**Subject: Transmittal Letter – CGS Comments
Proposed Multi-family Development
Venetucci Boulevard at South Academy Boulevard
Colorado Springs, Colorado**

Professional Service Industries, Inc (PSI), an Intertek Company, is pleased to transmit this letter in response to comments received by Colorado Geological Survey (CGS). PSI has provided a Report of Geotechnical Engineering Evaluation for the proposed multifamily development and issued a report dated January 2, 2025.

Comments from CGS were provided in a letter dated December 20, 2024. We understand a Geological Hazard Report will be needed, and PSI can provide a report following receipt of further design documents.

As Constructed	VENETUCCI BLVD. & B ST. EXISTING DRAINAGE MAP			Project No./Code	
	No Revisions:	Designer: SMH		PROJECT NO	
Revised:		Detailer: CAS		196825002	
Void:		Sheet Subset: DRAINAGE	Subset Sheet: 1 of 4	Sheet Number A

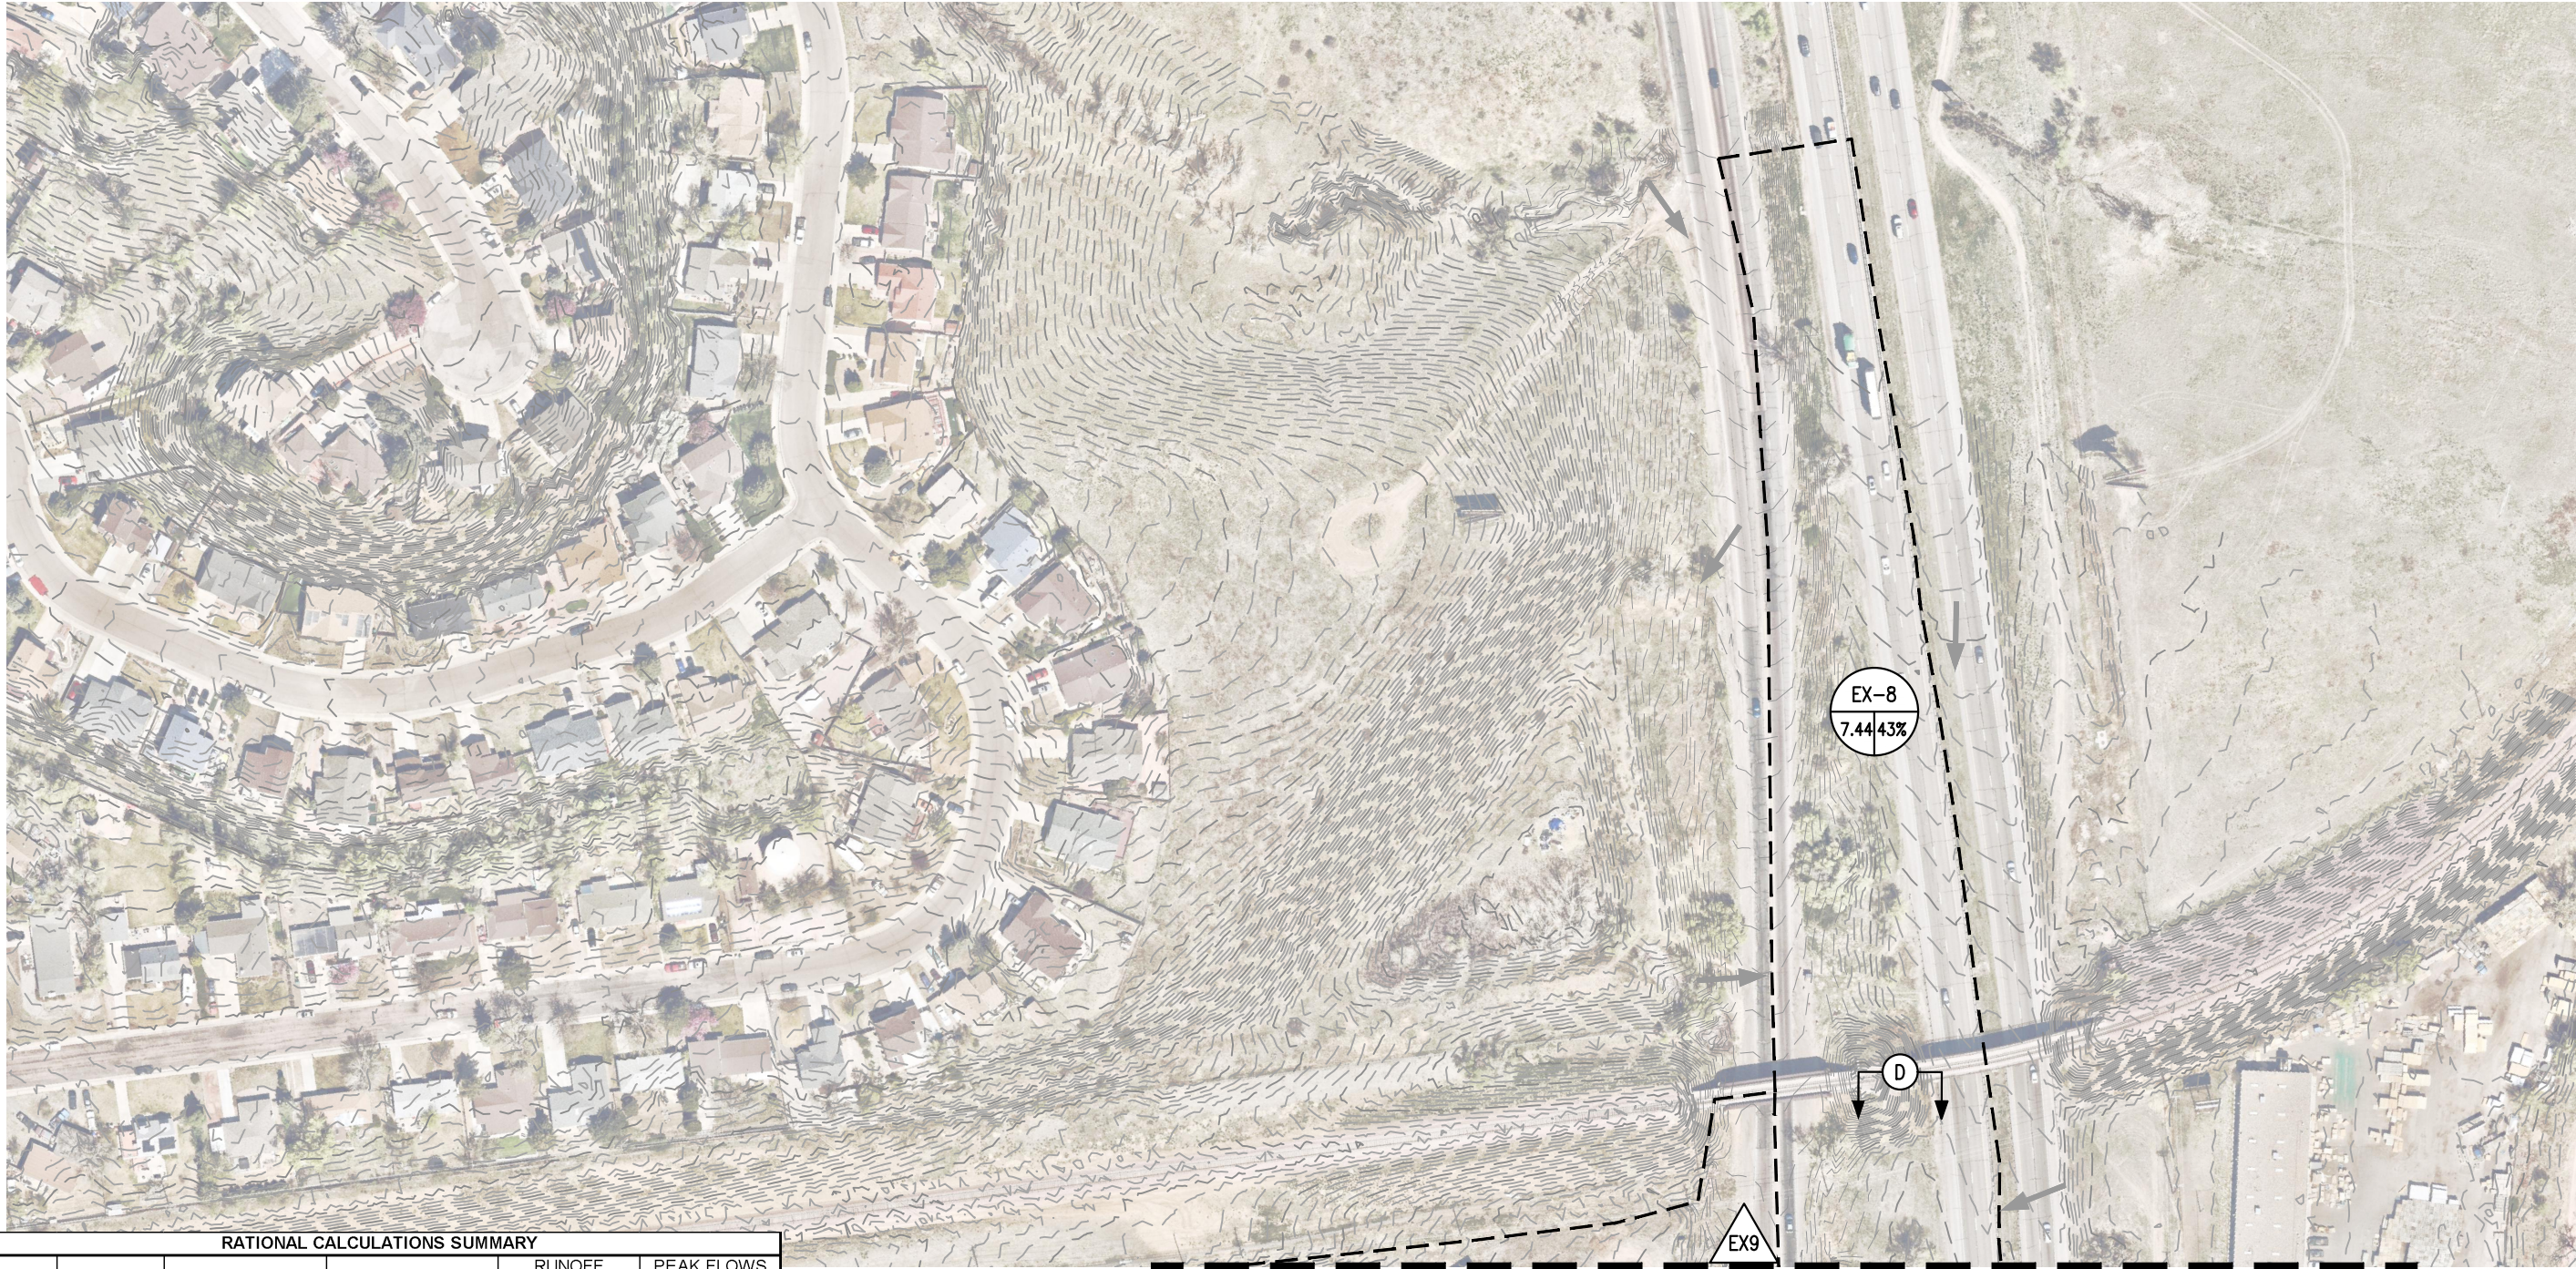
- Drainage Considerations: Clarify how water from historic groundwater flow will drain from the former valley now infilled, where the existing drainpipe will be removed (Existing Conditions Sheet C200).

- PSI did not observe groundwater during our geotechnical investigation with the exception of one boring at the bottom of the existing slopes. For the geologic hazard report, PSI will review site drainage plans. We will need to coordinate with the Civil Engineer in regard to drainage routing and its effects once design is complete.
